## Comments on the Applicant's D5 submissions

This document sets out the comments on the Applicant's Deadline 5 (D5) submissions by Cambridgeshire County Council (**CCC**), Huntingdonshire District Council (**HDC**) and South Cambridgeshire District Council (**SCDC**) (together, the **Councils**). The tables below set out the document in question that the Councils are commenting on, together with the relevant paragraph or reference number.

### 9.54 Barbastelle Bat Surveys and Mitigation Technical Note (Rev 2) [REP5-006]

Filename: W:\Active Projects\A428\GIS\02\_Maps\A428\_GCNI\A428\_GCNI\_C3.2a\_Survey.mxd

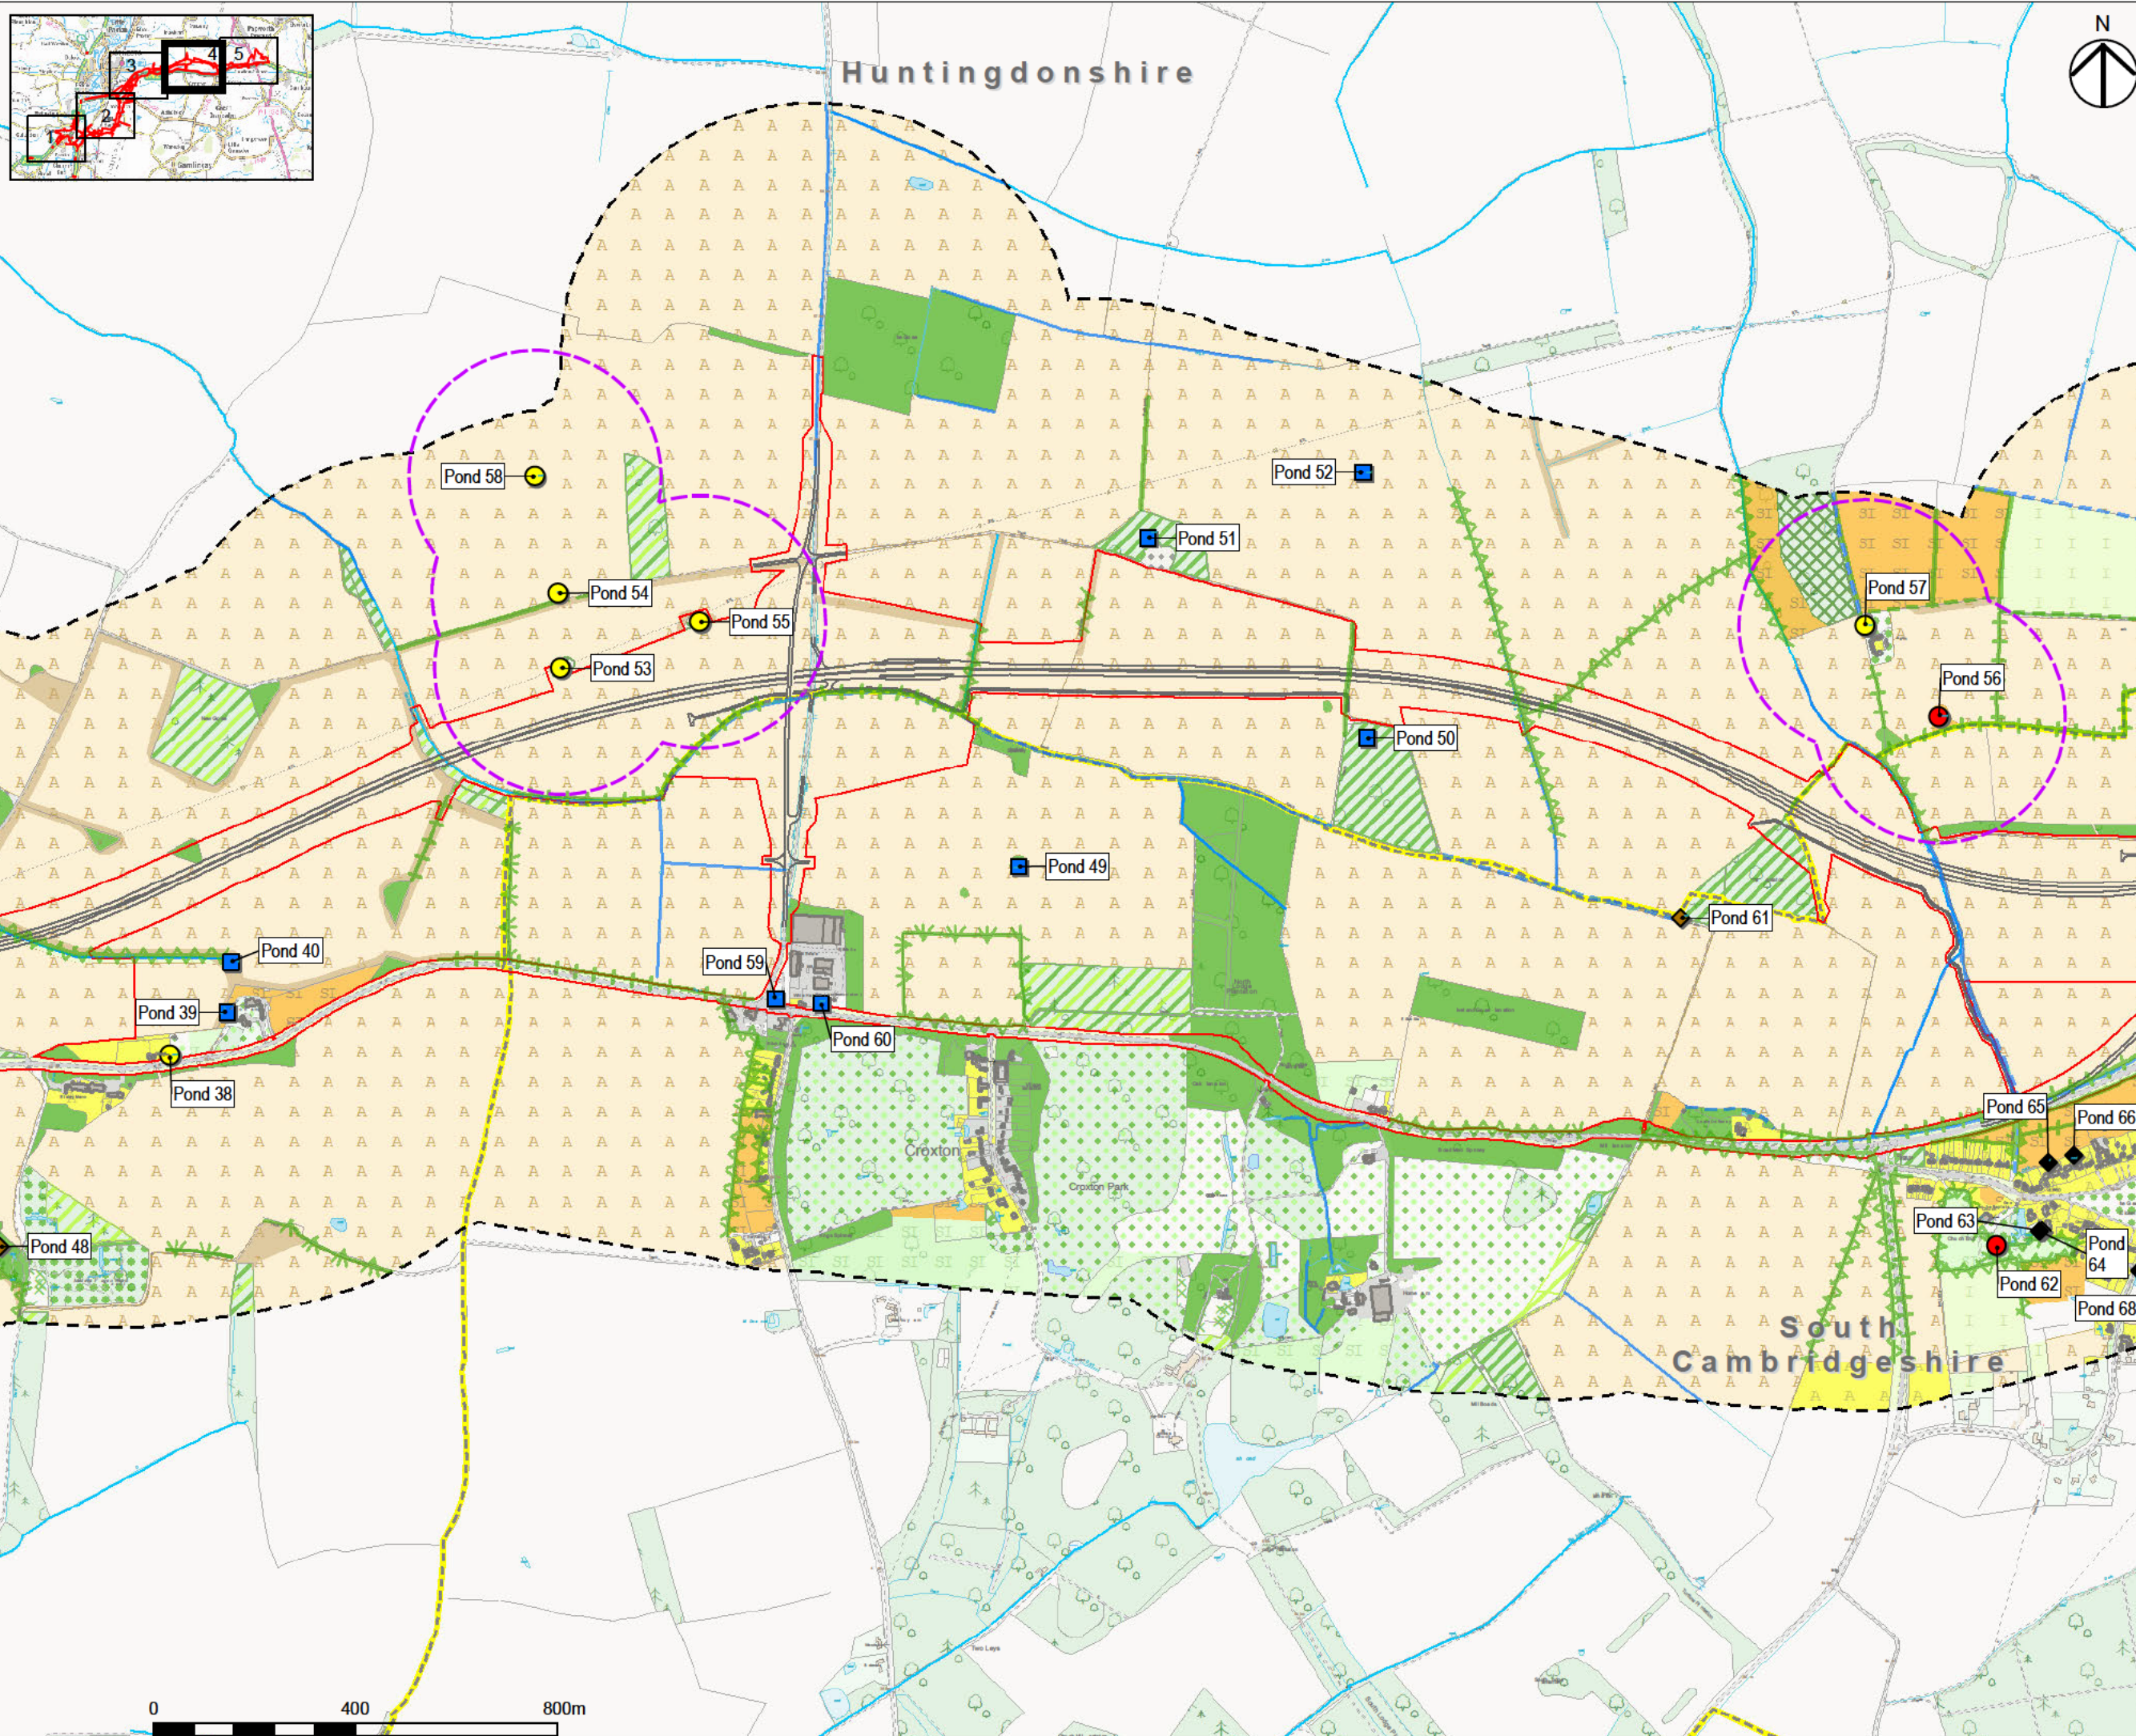
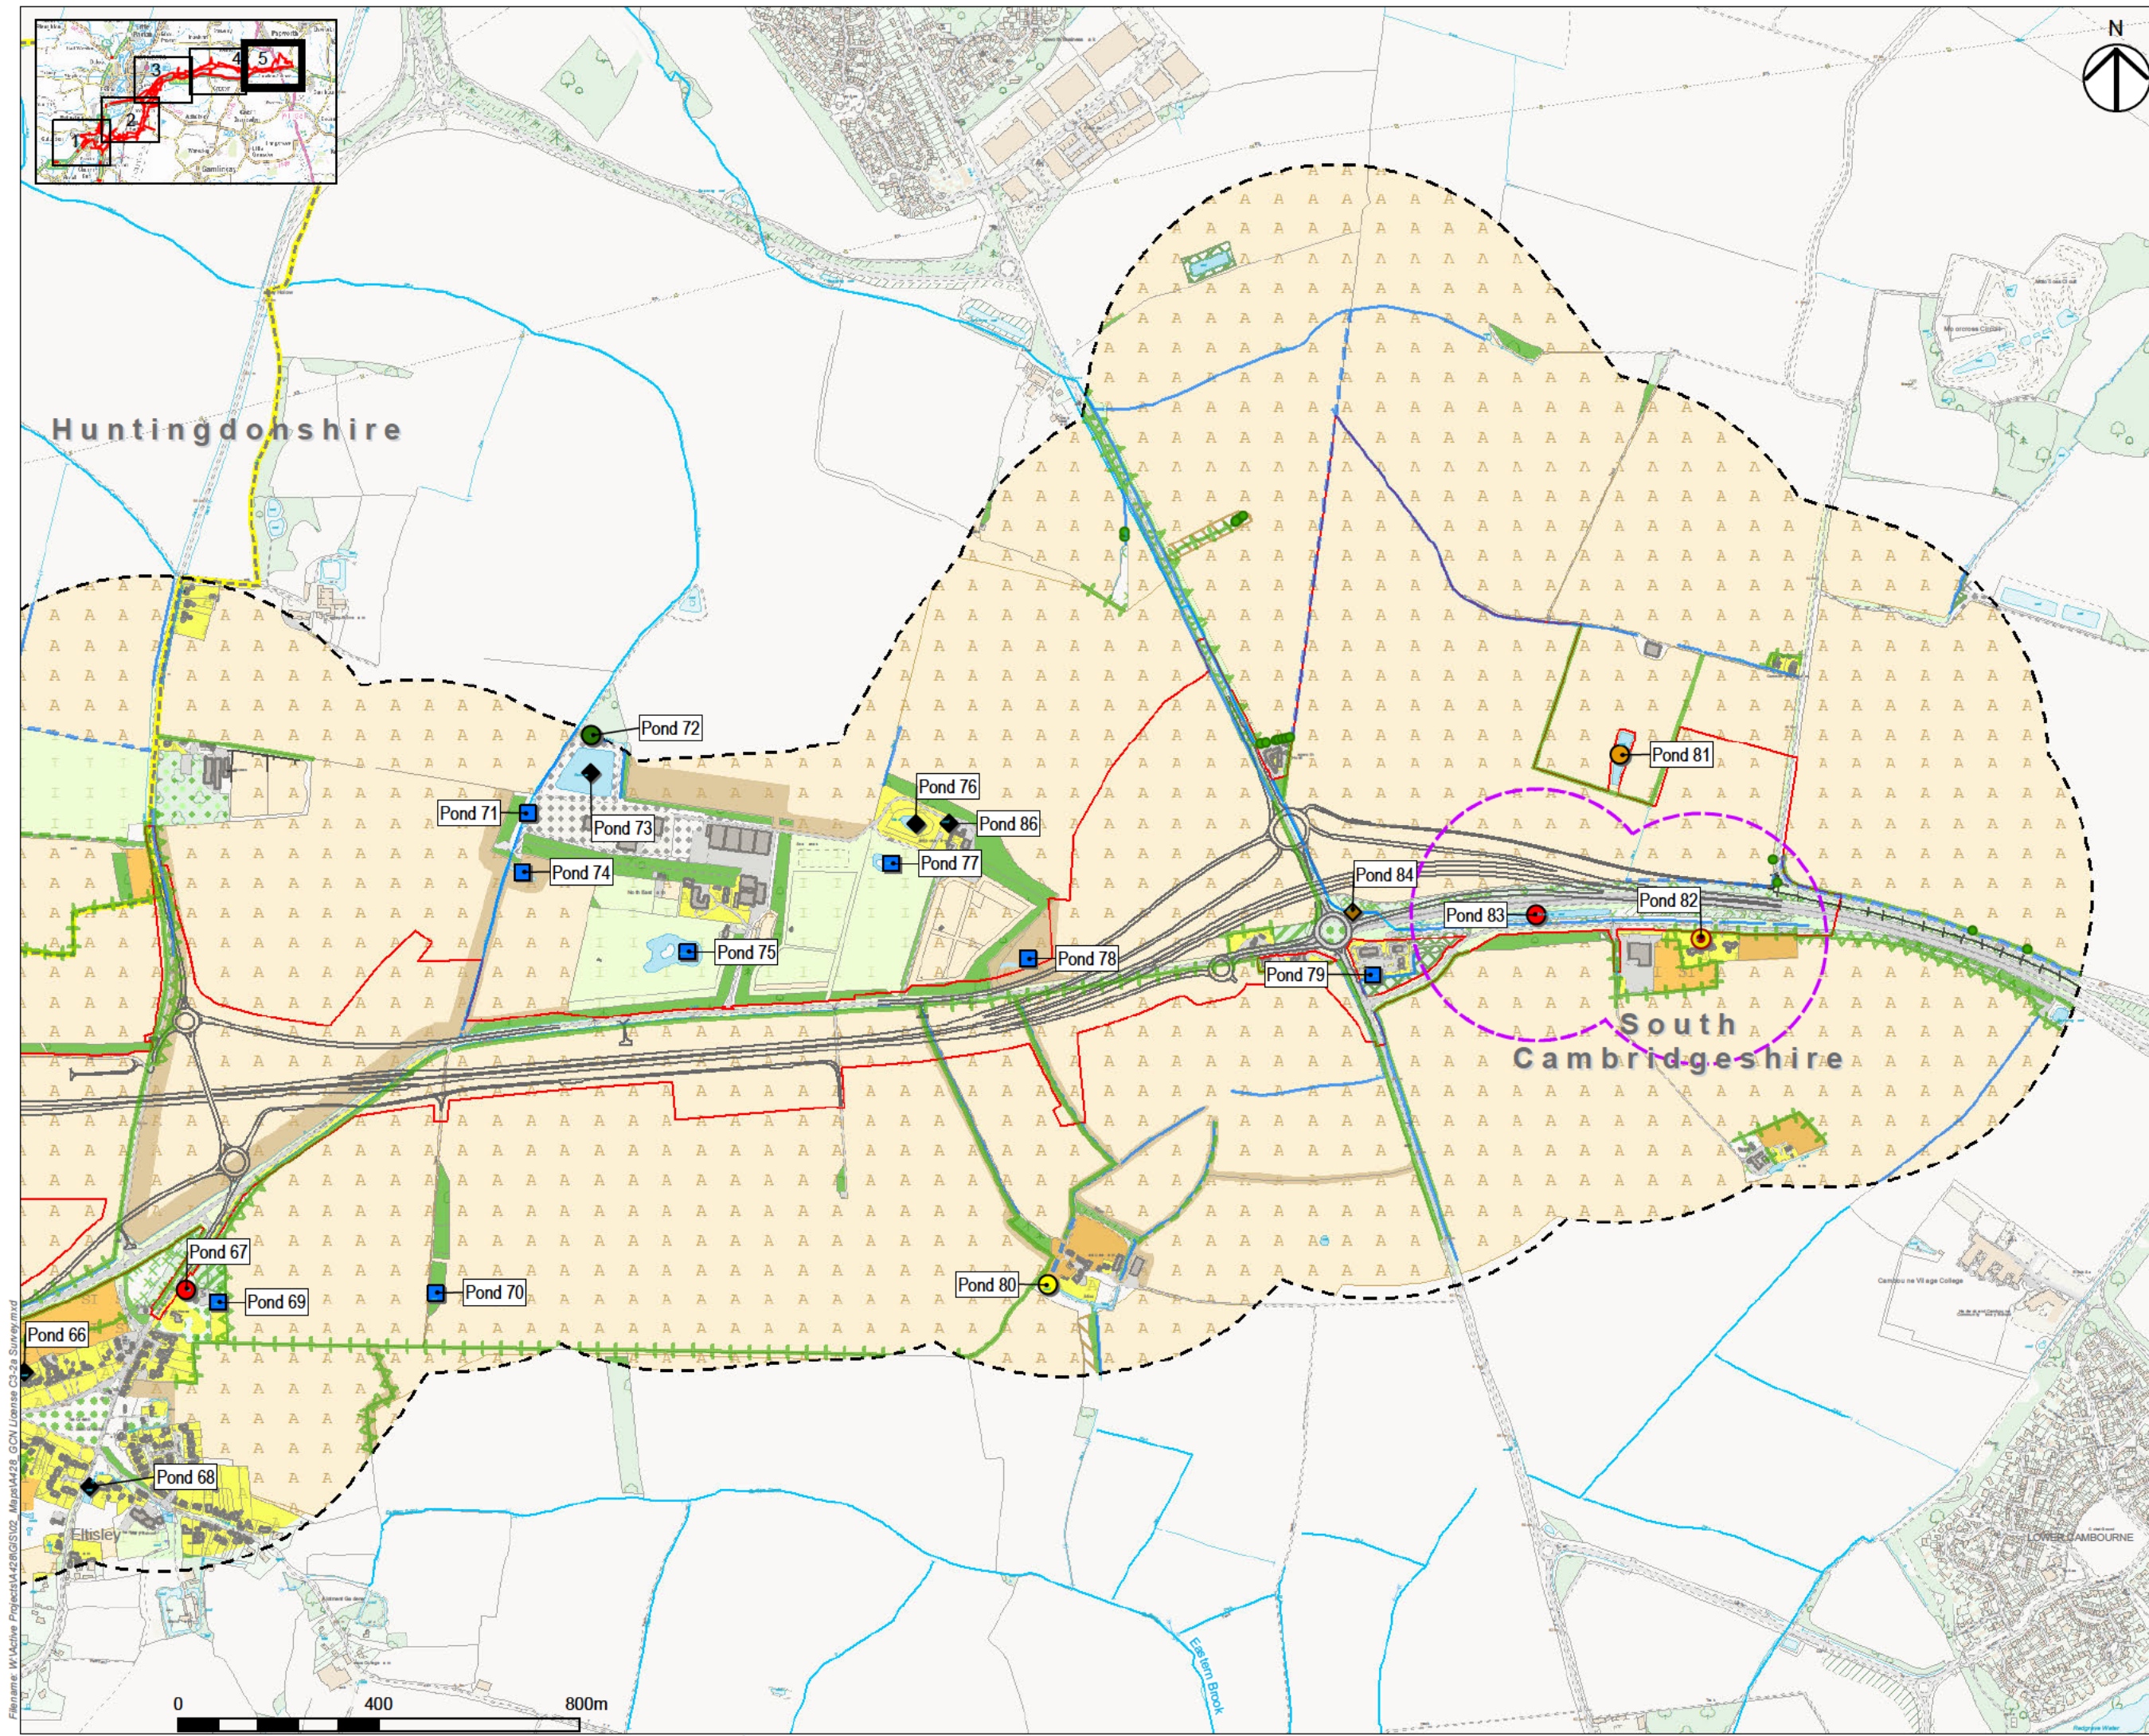
Pond 84	7.3.1	<p>Pond 84 is one of two ponds that will be lost in Cambridgeshire as a result of the proposed development.</p> <p>Pond 84 was found to be dry in 2021. We support National Highways conclusion that the pond is unlikely to support any regular breeding by Great Crested Newts. Therefore, this addresses our previous concern with regards to the loss of this ponds for GCNs.</p>
---------	-------	---
